# WEST MIDLANDS INTERCHANGE

## Transport Technical Note 46 – A449 / A5 Link Road Signalised Crossing

| <b>Subject</b>      | A449 / A5 Link Road Signalised Crossing (Final) |                       |                 |

FIGURE No: **FIGURE T7**

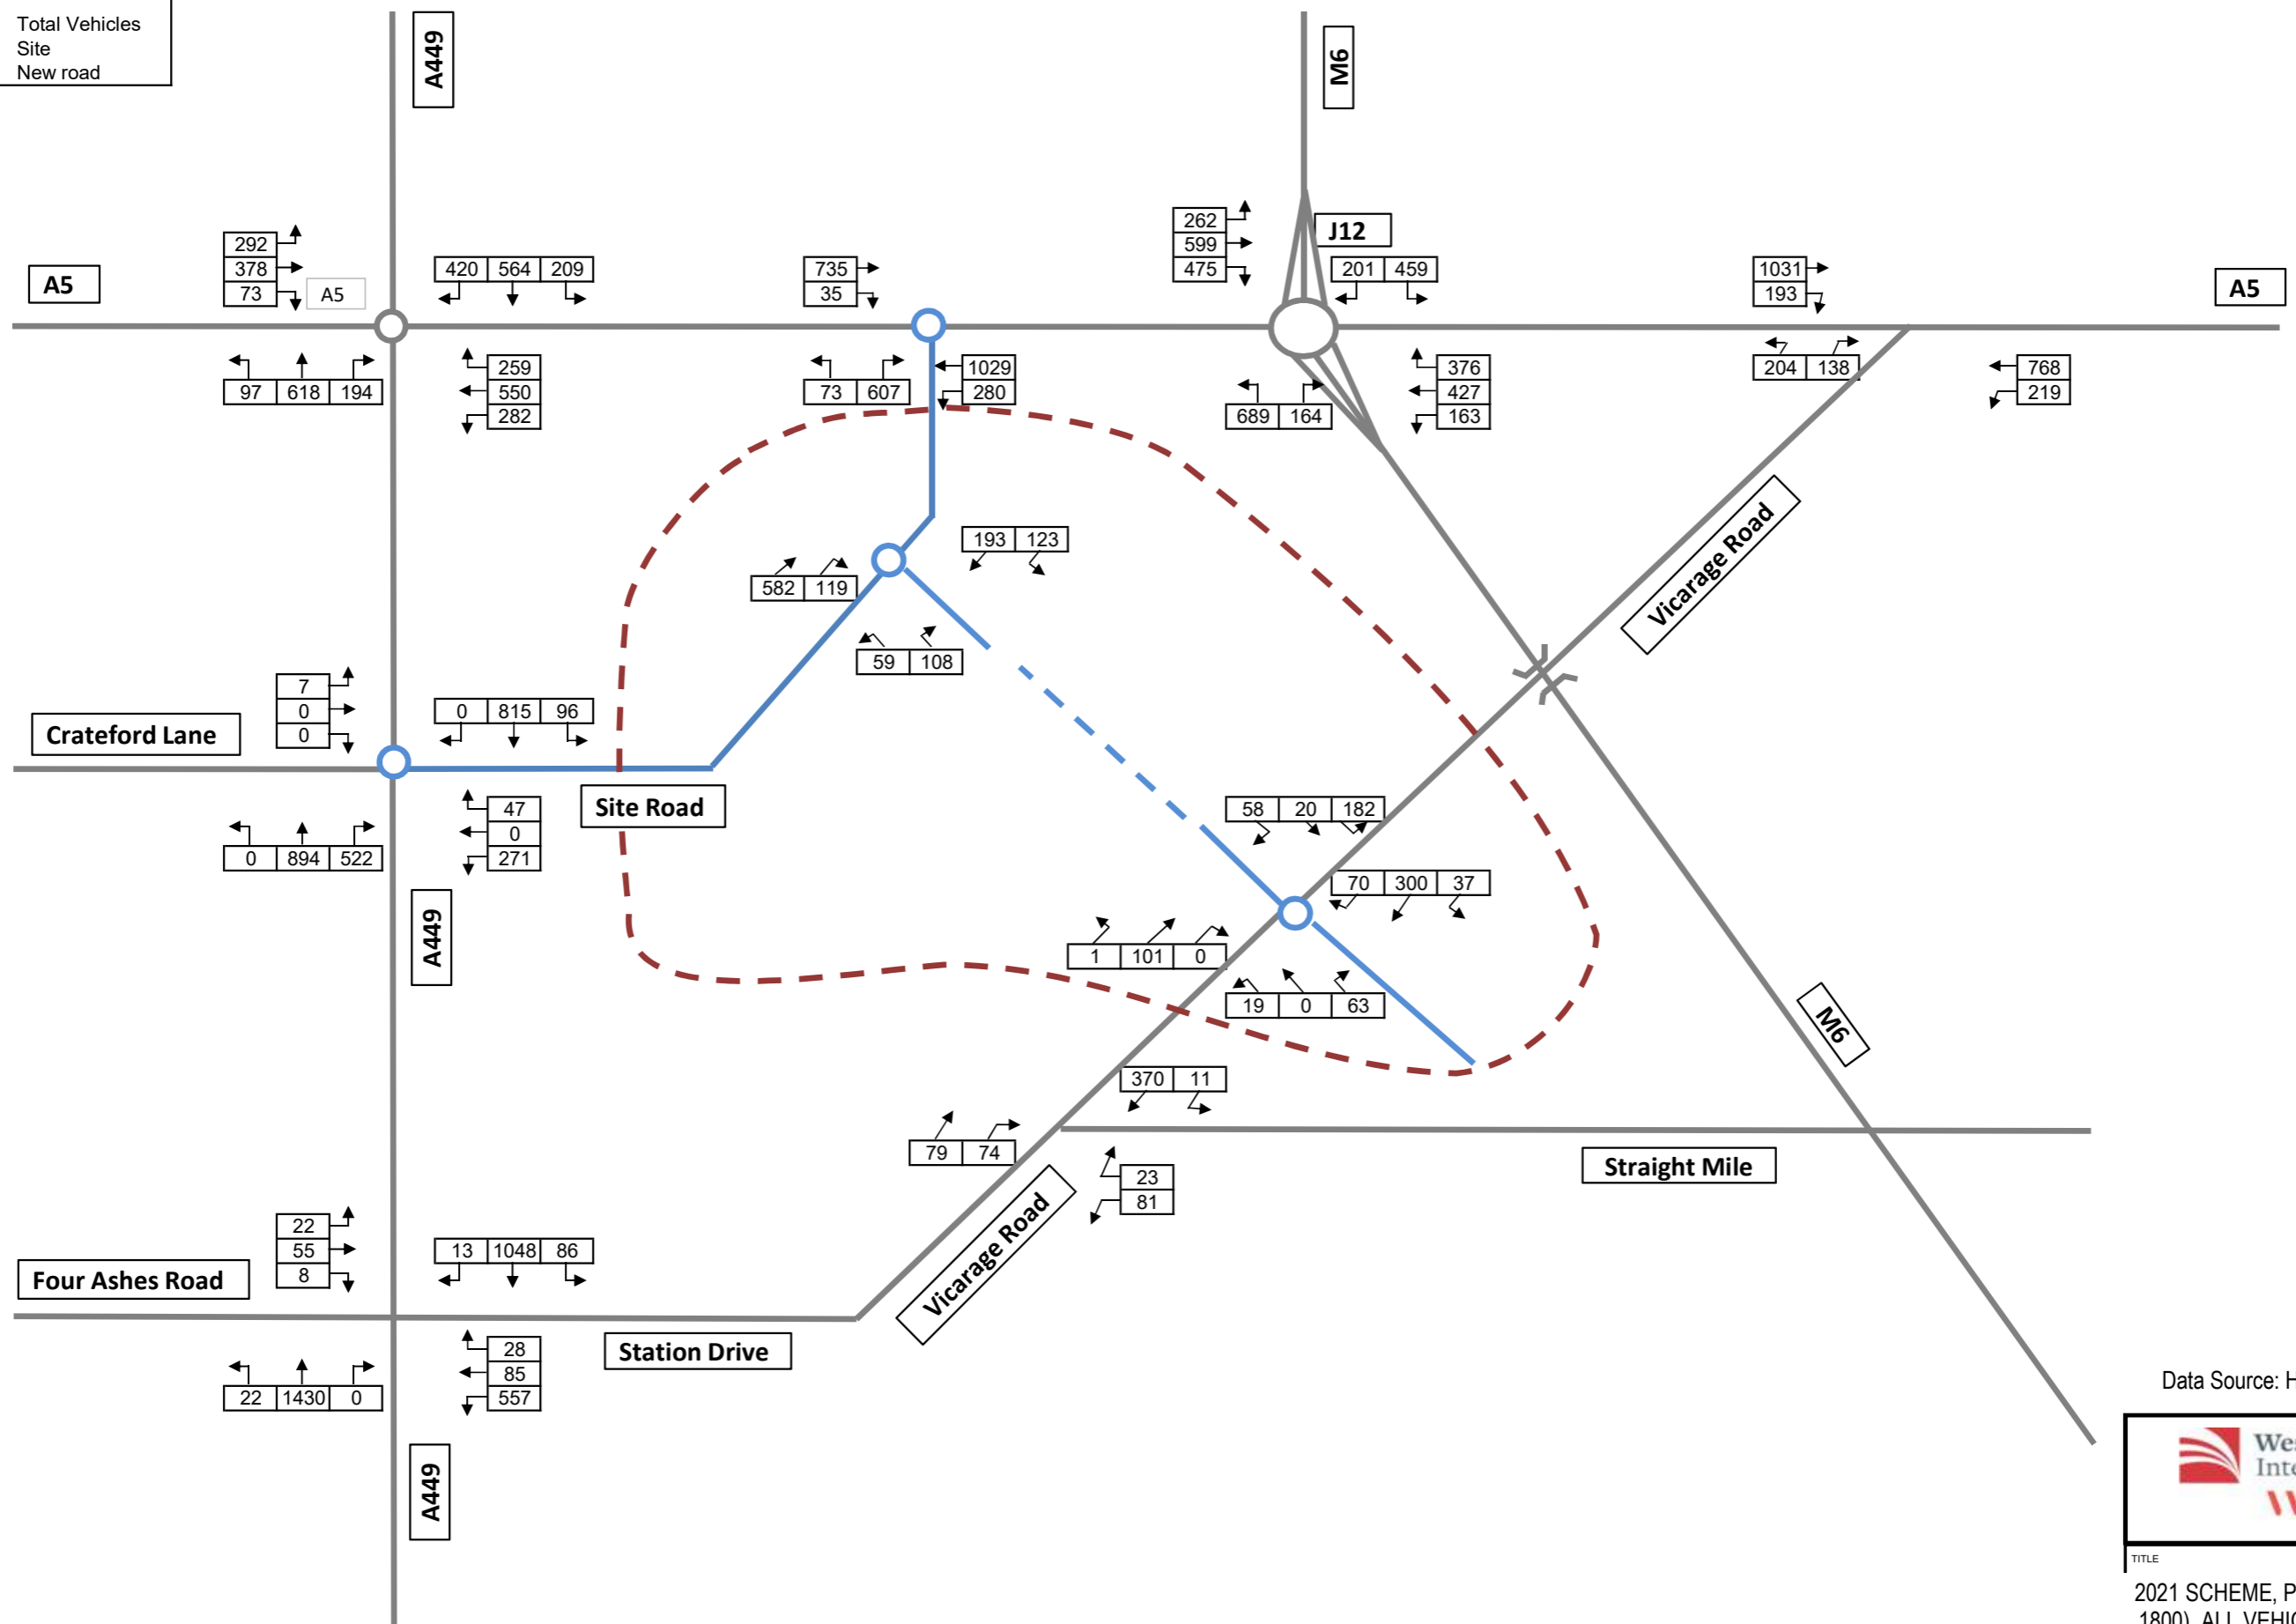
- 2.5 As the traffic flow approaching the crossing consists of streams of traffic approaching from both the north and the south. By reference to Figure T7, provided within Appendix Q of the scheme Transport Assessment (**APP-146**), provided at Annex 5), 15% of traffic using the link road during the PM peak would have an origin from the north. On the basis of the maximum PM queue of six PCU's and that a proportion of 15% of the vehicular demand will originate from the north it is reasonable to assume that at least one PCU of this queue will also be from the north. With the provision of the keep clear markings, any residual queueing traffic from the north would be accommodated on the A449 south bound approach to the junction.
